**From:** [Jeremy Johnston](#)  
**To:** "Ed Sewall"; [Spencer Parr](#)  
**Cc:** [Kelly Bacon \(CD\)](#); [Jeremy Larson](#)  
**Subject:** RE: Swiftwater Storage CUP and Residential Building Application Parcel 15445  
**Date:** Tuesday, May 25, 2021 2:26:29 PM

Thank you for the clarification, this is helpful. I do have to note that these wetland areas are considered contiguous to a Shoreline and therefore the buffers must be drawn from KCC 17B.50.020G-1, For Category 2 wetlands. These buffers are as follows:

The Commercial Use being proposed under the Swiftwater CUP would be considered a High Intensity Use, which requires a 200 foot structural setback. We will need an updated site plan from the applicant which indicates these updated setback boundaries.

WLC PROPERTY HOLDINGS LLC
SITE PLAN

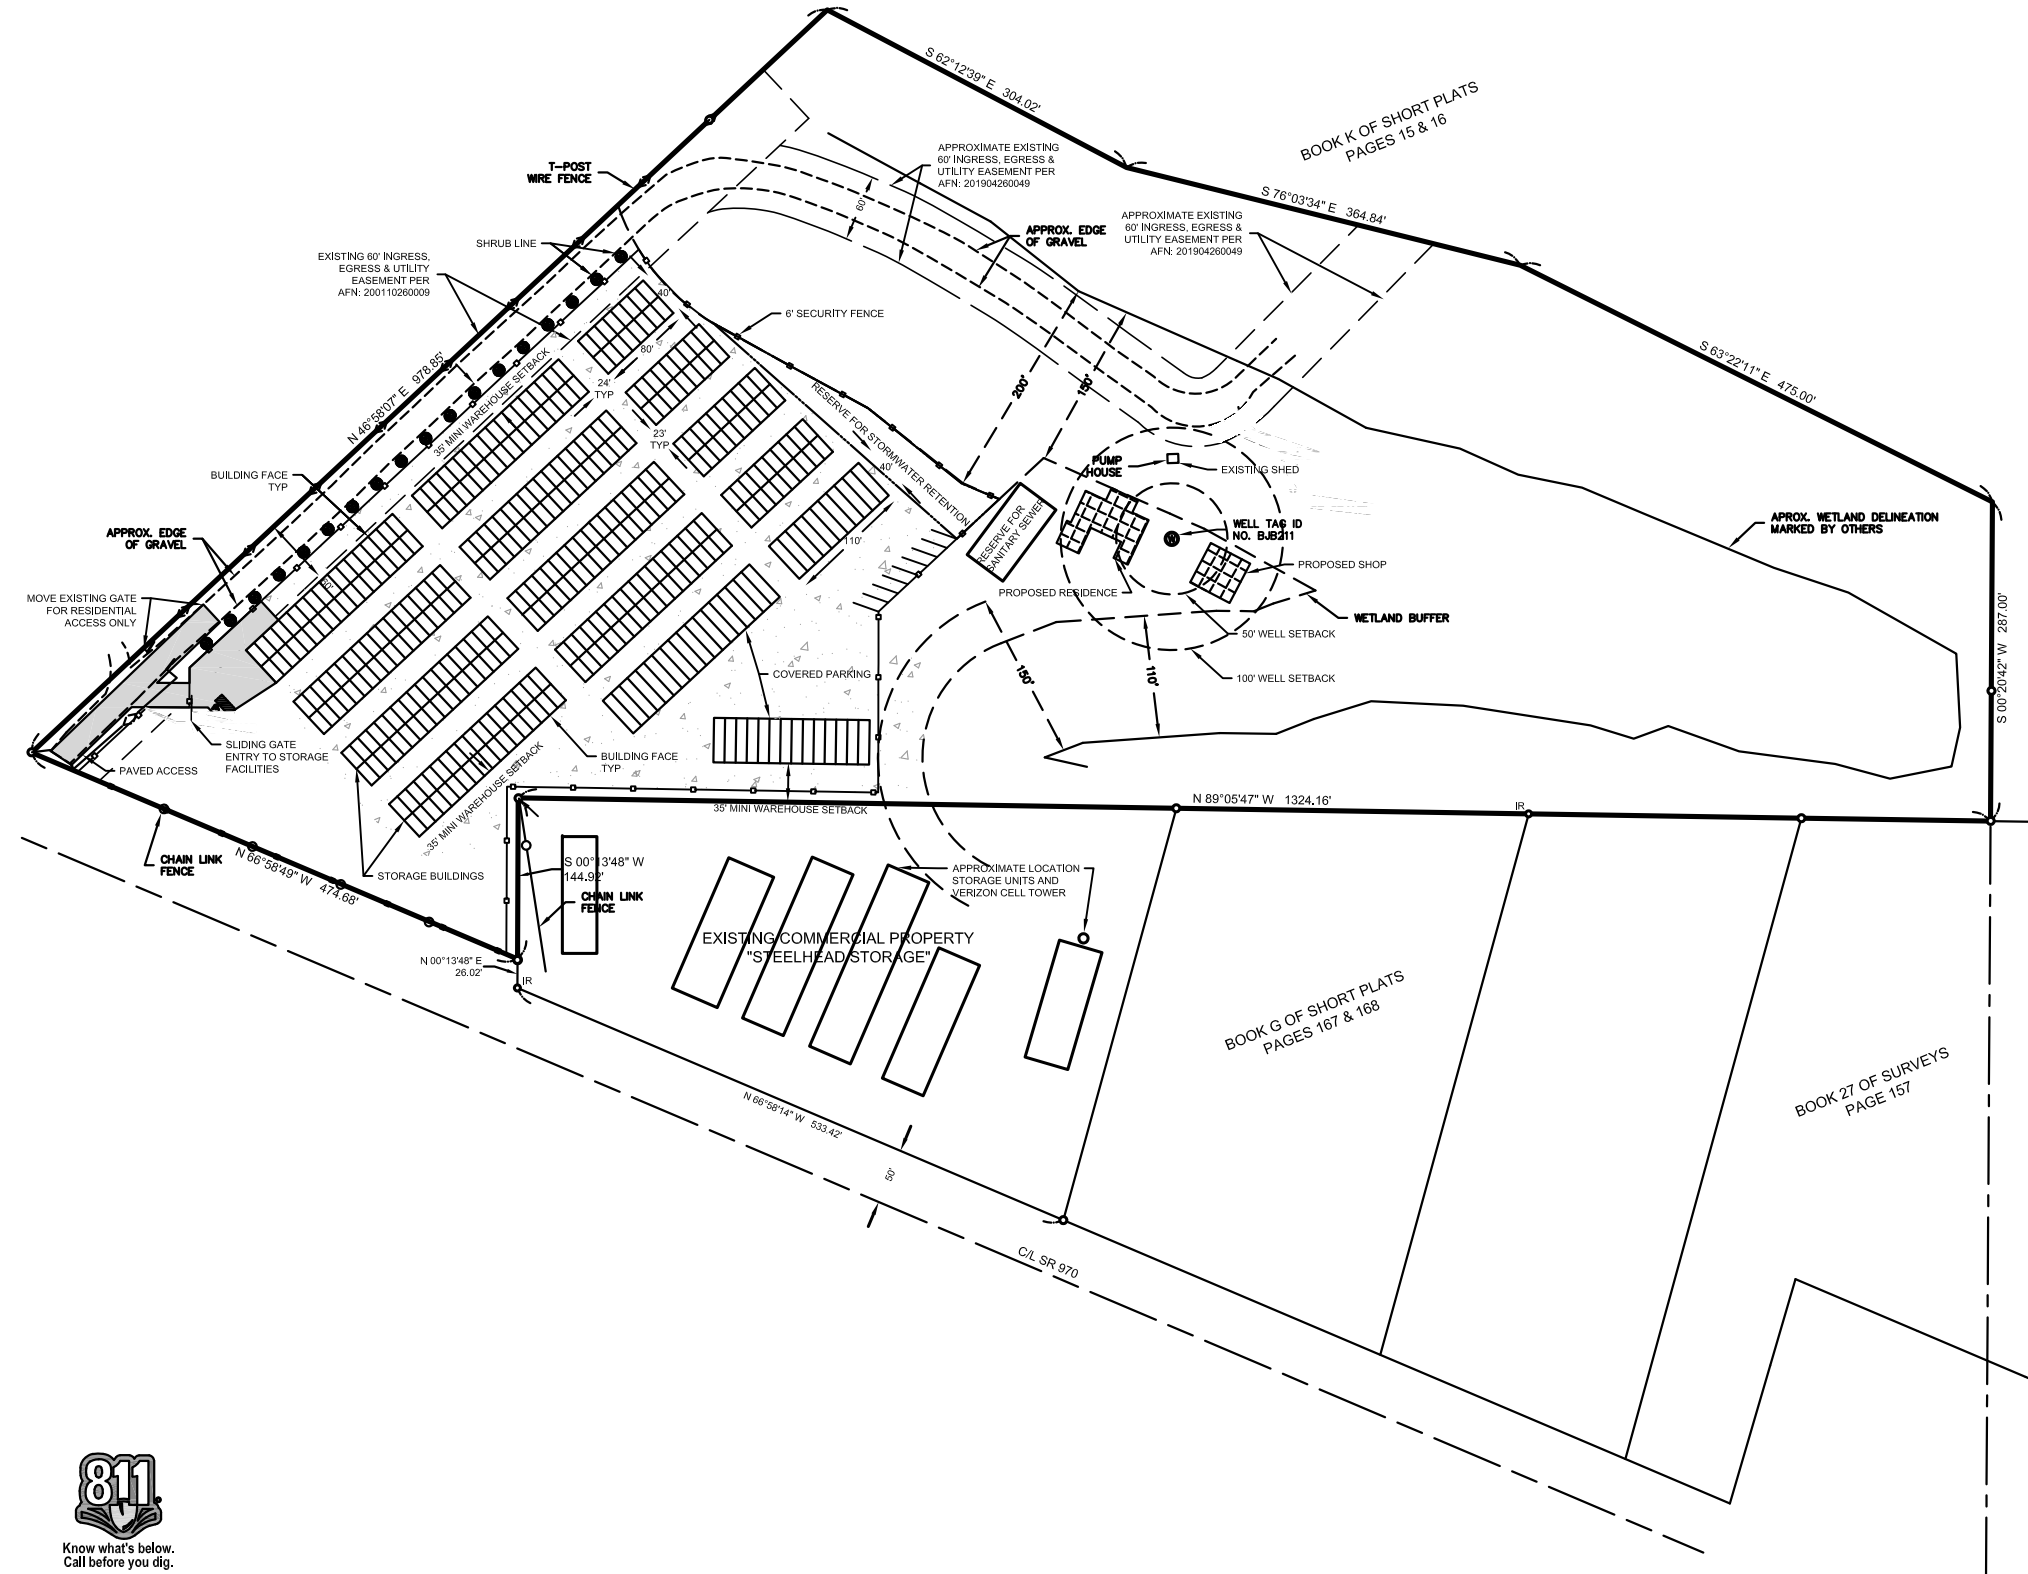
As a side note, regarding the proposed residence on the parcel, the site plan will need to be updated as well for this building application. In this case the residence is considered a moderate intensity use which will require a 150 foot structural setback (see table above). Depending on the precise location of the residence, in reference to this setback line, a Shoreline Exemption may be required.

WLC PROPERTY HOLDINGS LLC
SITE PLAN

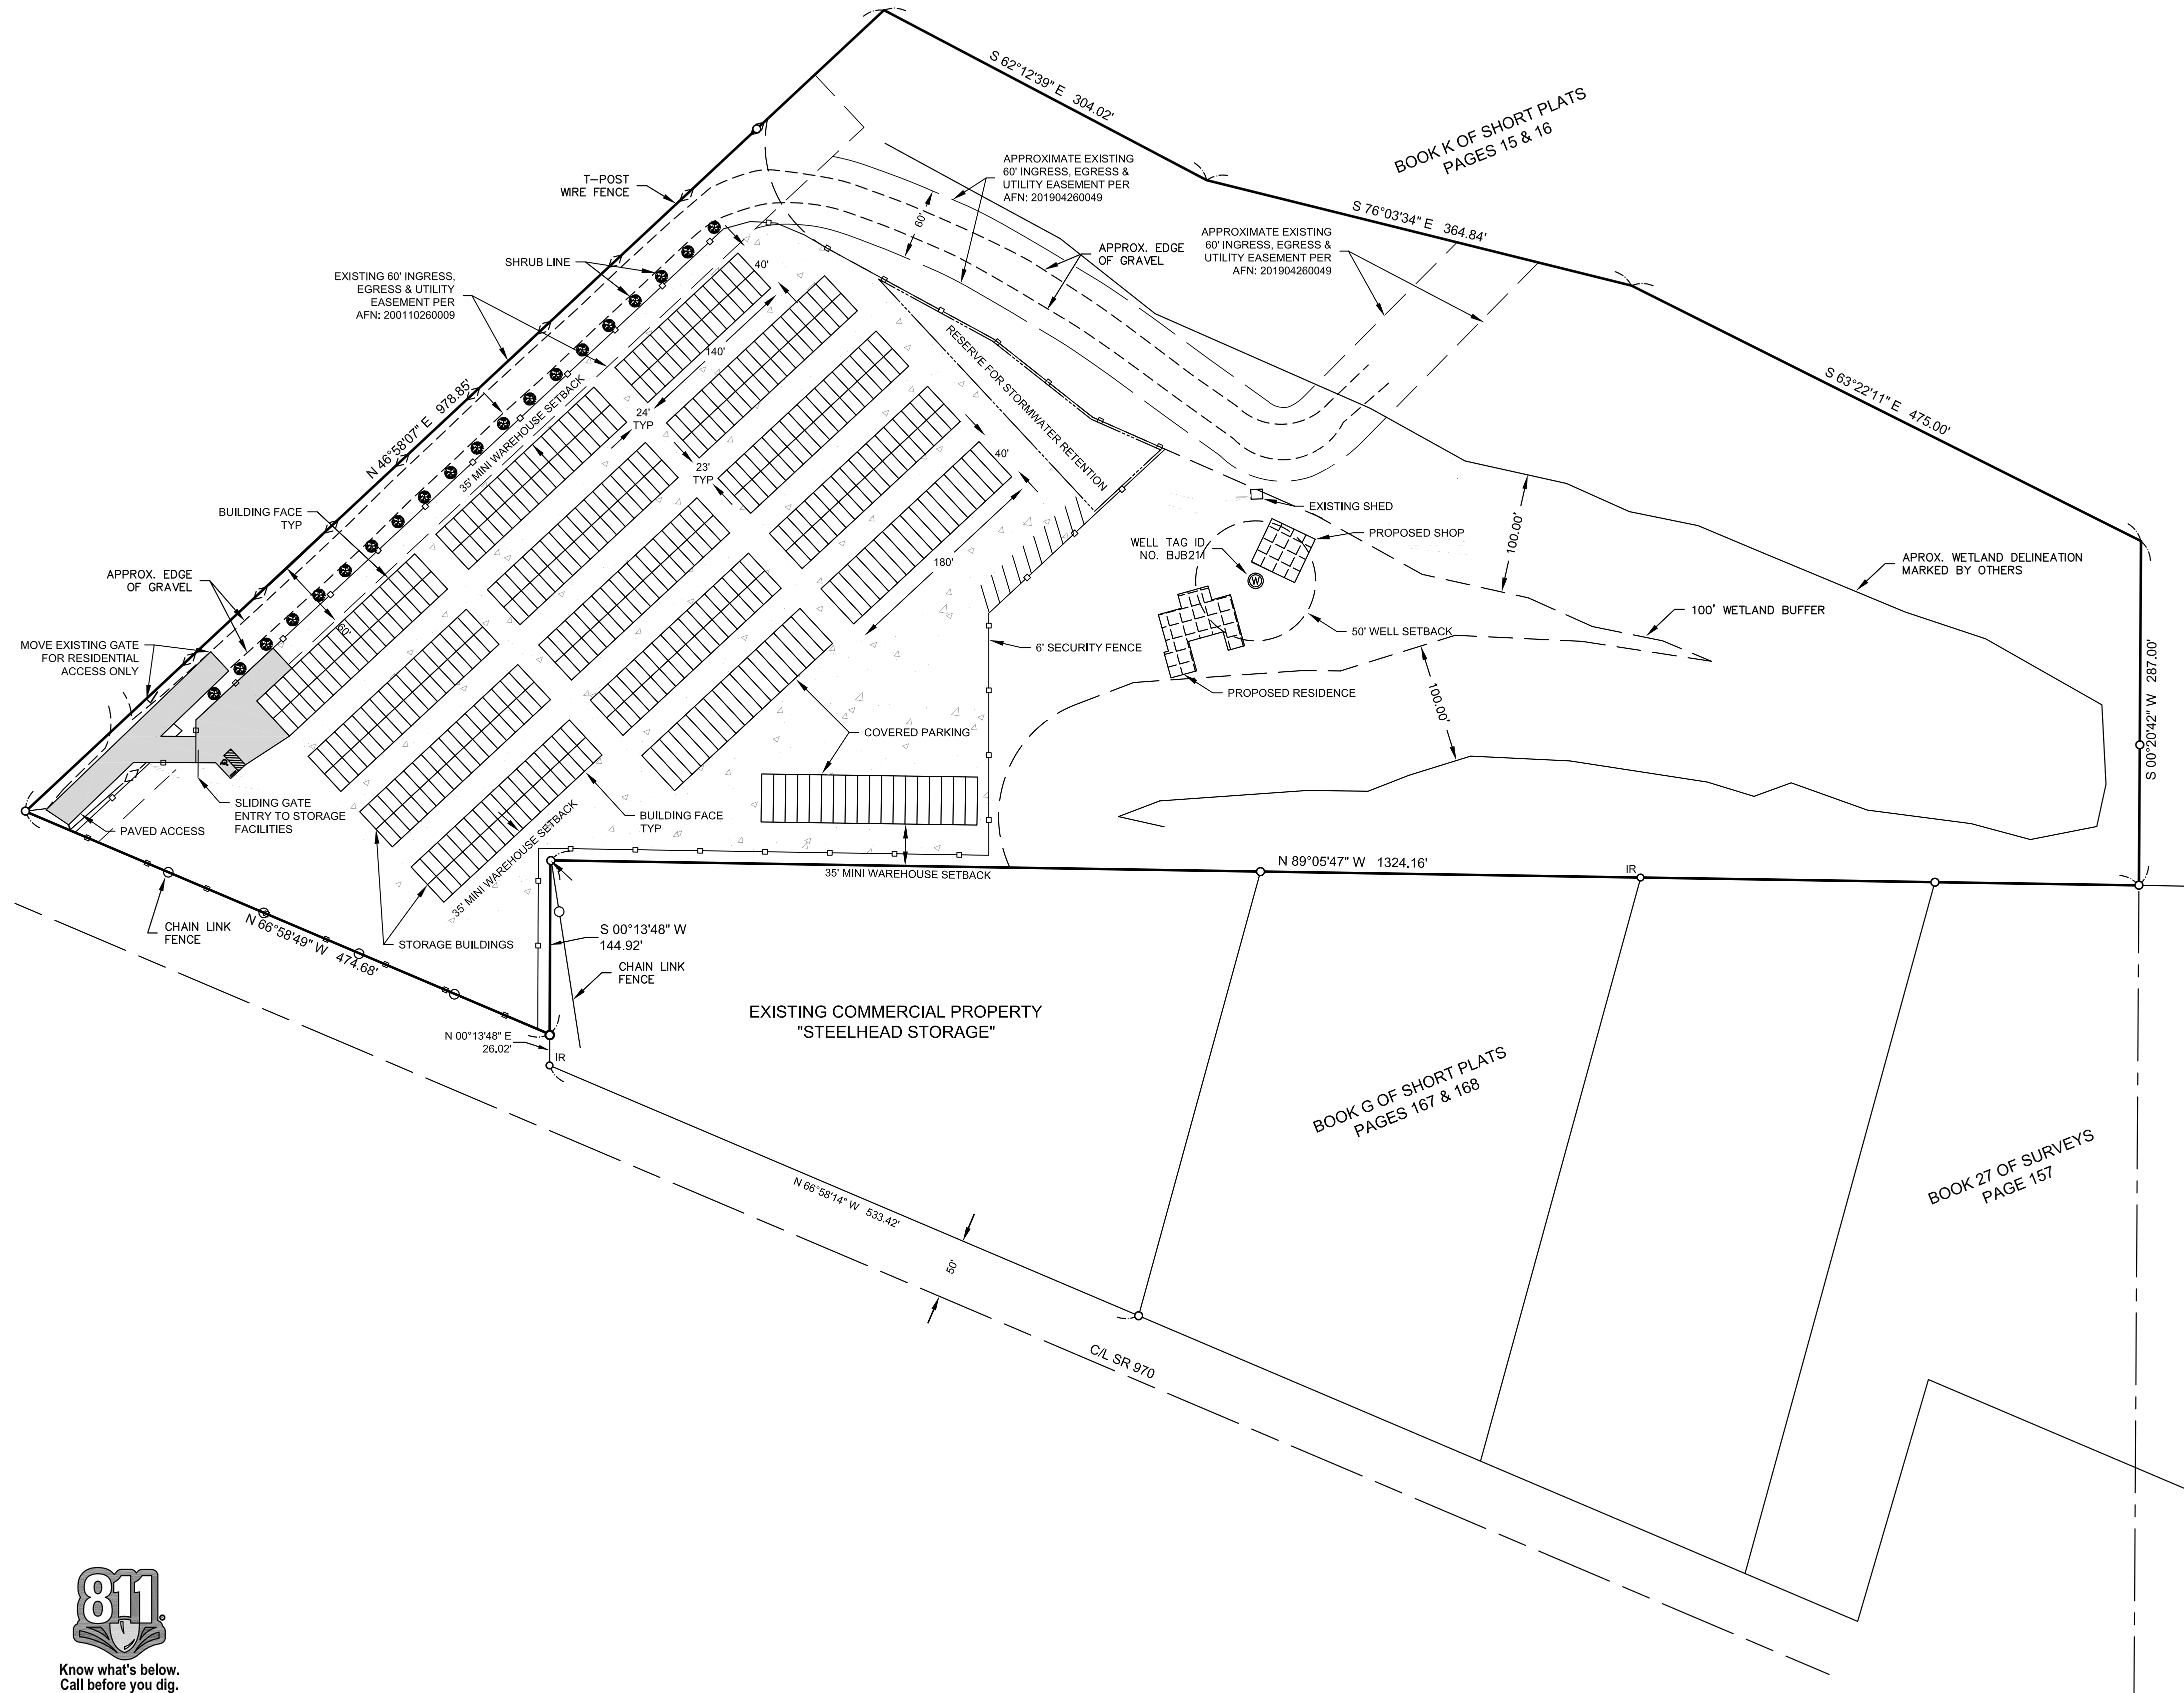
Please provide the updated site plan for the Swiftwater CUP to Kelly Bacon (CC'd) in this email. The updated site plan for the residence can be sent to myself and Jeremy Larson in CDS Building (Also CC'd in this email). Once I am able to review the updated residential site plan I will let you know whether a Shoreline Exemption is necessary.
